From: Contact Centre (CRM) <contact@ribblevalley.gov.uk>
Sent: 19 April 2022 08:32
To: Planning
Subject: Planning Application Comments - 3/2022/0271

Planning Application Reference No.: 3/2022/0271

Address of Development: Land Off Preston Road Ribchester PR3 3XL

BOADICEA Park, Ribchester
EXTERNAL MATERIALS

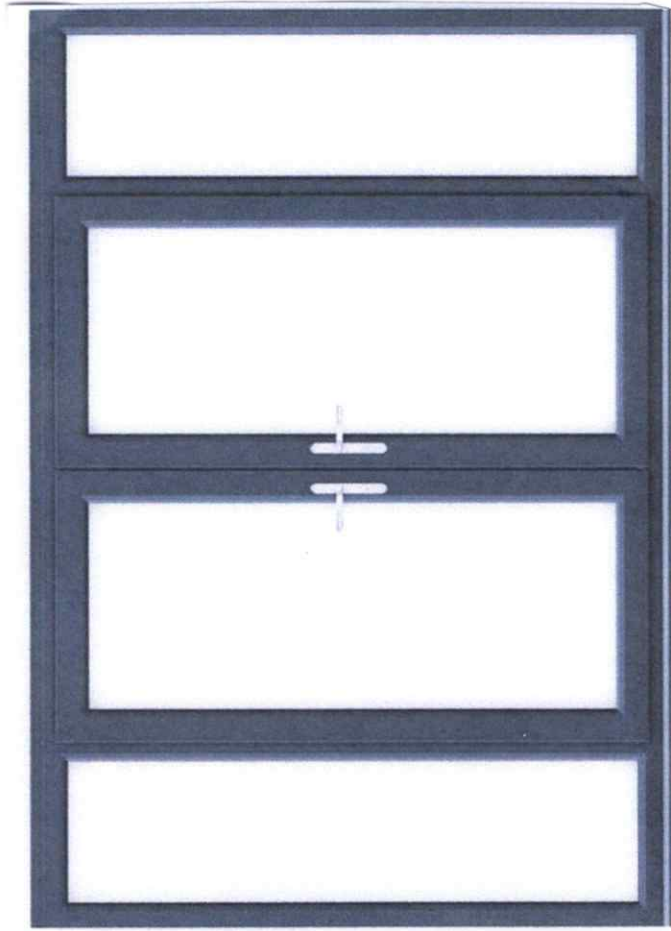
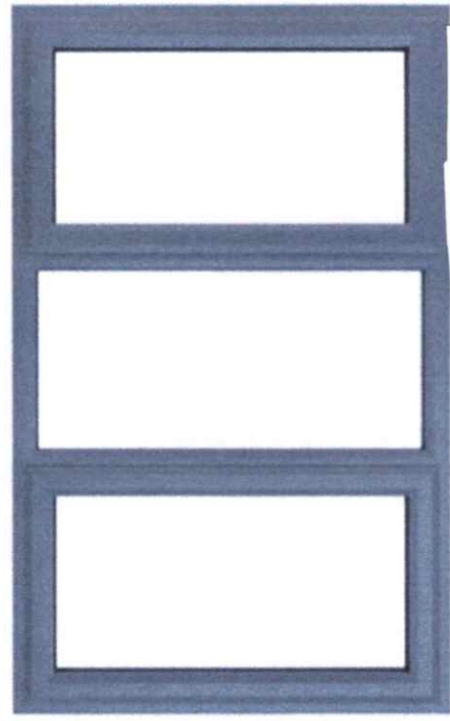
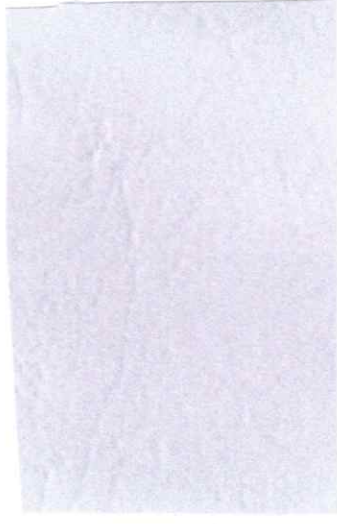
Comments: The proposed variation of condition 2 (plans) and Removal of Condition 9 Off site works of application 3/2021/0595 should not be allowed. The external facing materials proposed are not in keeping with the landscape colour goosewing grey and slate blue will stand out as an eyesore to the properties surrounding and the green countryside the building sits within. I note also the position of 2 lodges and would ask for what reason. There are changes to the number and arrangement of windows which which I am concerned may impact on the privacy of the houses in the vicinity. I note the request for variation of condition 9 - the works has started and the required action does not appear to have been taken - it is unclear to me what the proposed variation to condition 9 is of what the impact might be I would ask that this be clarified.
